Subject: Re: CLARIFICATION REQUESTED PLEASE - 8 St Richards Drive, Aldwick. AW/136/22/HH

Subject: PLANNING SOLUTION - 8 St Richards Drive, Aldwick.
AW/136/22/HH
Importance: High

East (side) elevation | proposed

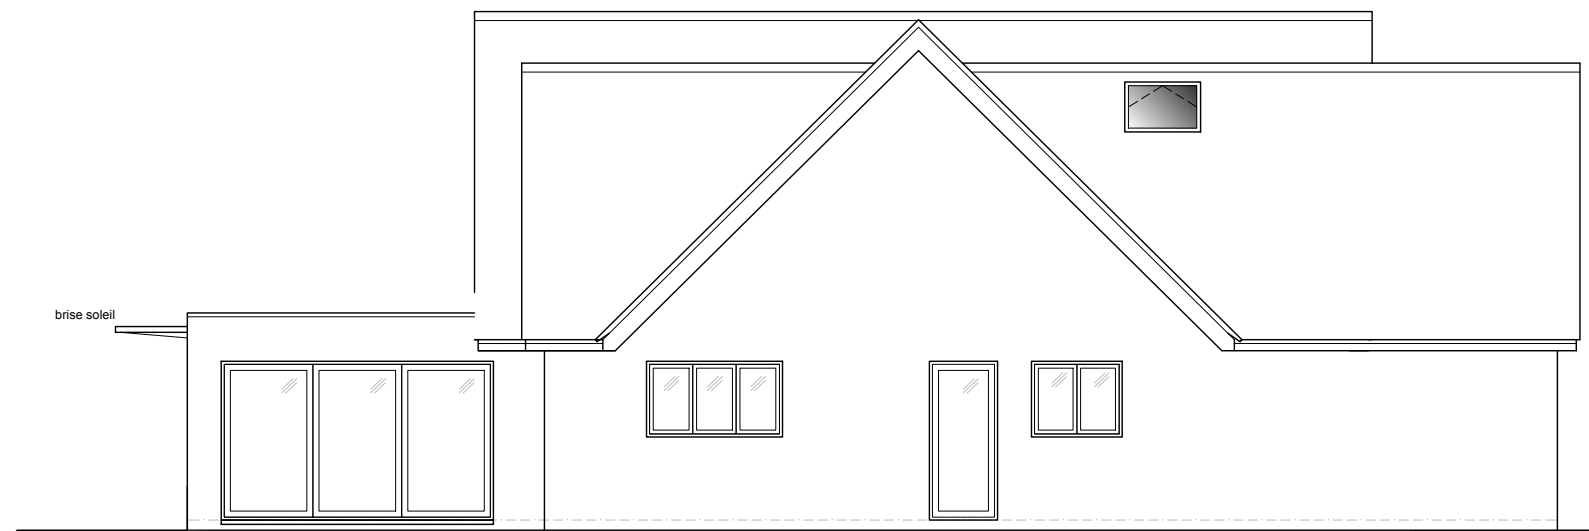
I have discussed the amended plans with my manager however we will still be recommending refusal as we don't believe it sufficiently addresses the concerns of overbearing.

"My main concern is the overbearing and likely overshadowing caused by the roof extension to the garage. I attach a photo taken from the neighbouring property to help show the context."

This relates to the gable end on the east elevation (side) facing the neighbouring property (number 10).

The proposed eaves height matches the existing, and the main roof plane running north/south above the garage rises away from number 10, which matches the angle of the existing pitch roof.

My main concern is the overbearing and likely overshadowing caused by the roof extension to the garage. I attach a photo taken from the neighbouring property to help show the context.

Therefore, to minimise wasted time and resources for all involved, could I suggest an alternative option, omit the half hip, and gable end, so the roof facing East and Number 10 is a consistent straight run of roof from the front of the building to the back?

- A reduction in the volume of the first floor extension could be achieved by changing the gable to a half-hip gable matching the angle of the main roof plane and moving the highest point of the ridge by an additional circa 2 metres from number 10. I have sketched over the proposed drawings to reflect my suggestion.
